EN010125: Application by RWE Renewables UK Dogger Bank South (West) Limited and RWE Renewables UK Dogger Bank South (East) Limited for the Dogger Bank South Offshore Wind Farms Project

The Examining Authority's further written questions and requests for further information

Issued on Tuesday 13 May 2025

Figure: 2-2	Drawing No: PB2340-MAR-OF-ZZ-DR-Z-0013	
Co-ordinate system: WGS 1984 UTM Zone 31N	Page Size: A3	Scale: 1:950,000
Project: Dogger Bank South Offshore Wind Farms	Report: Heat Mapping Report: Atlantic Herring and Sandeel

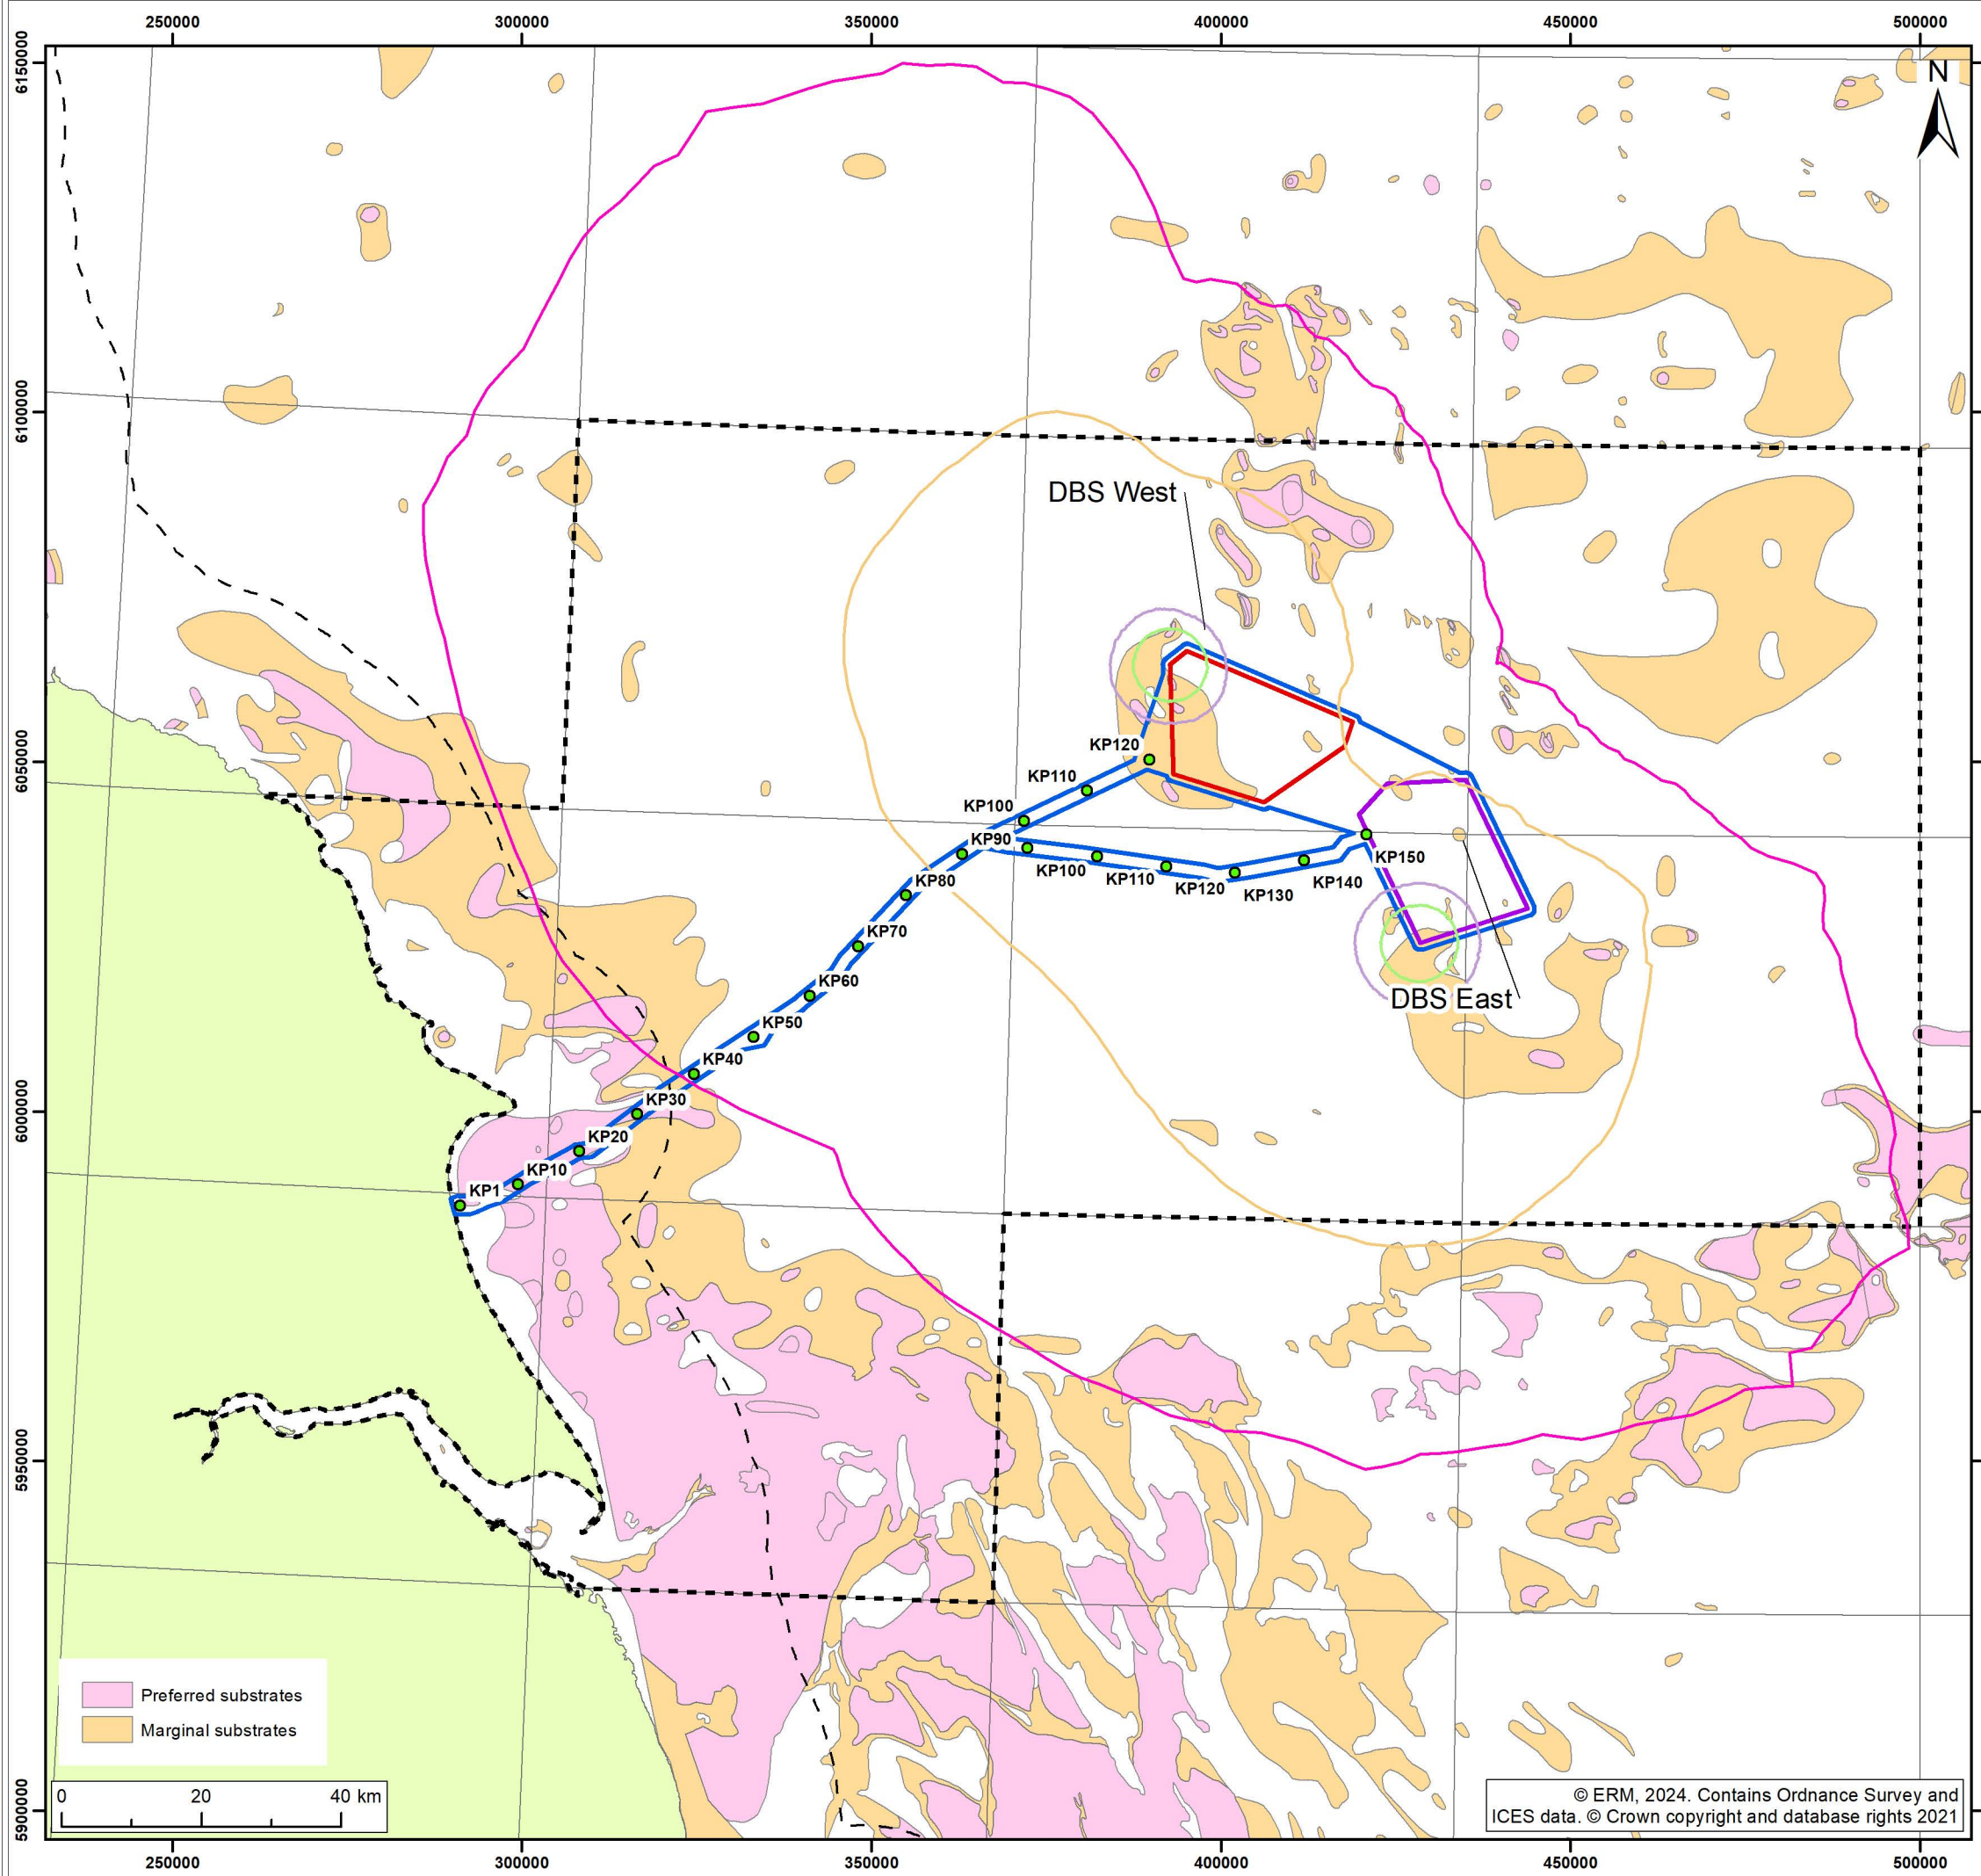
FSE.2.5	The MMO	<p>Atlantic herring heat map</p> <p>The applicants state in their summary of representations at ISH5 [REP4-086], that the 135dB disturbance threshold is inappropriate to the assessment of herring and dispute the claim that the 135dB limit establishes the best available scientific evidence but rather that it represents preliminary findings to inform a more comprehensive behavioural disturbance metric in future studies and that the greatest range at which an impact should be considered for herring is 186dB. The applicants state further in the same reference that there is no evidence in Hawkins et al. (2014) or Popper et al. (2014) that shows that 135db would have an impact on herring spawning behaviour, going on to state that they do not consider that relying on Hawkins et al. (2014) is appropriate or justified as the authors note themselves that it should not be used in the way purported by the MMO or NE. Please explain the MMO's view of the relevance of the 135dB disturbance threshold and the 186dB TTS threshold.</p>
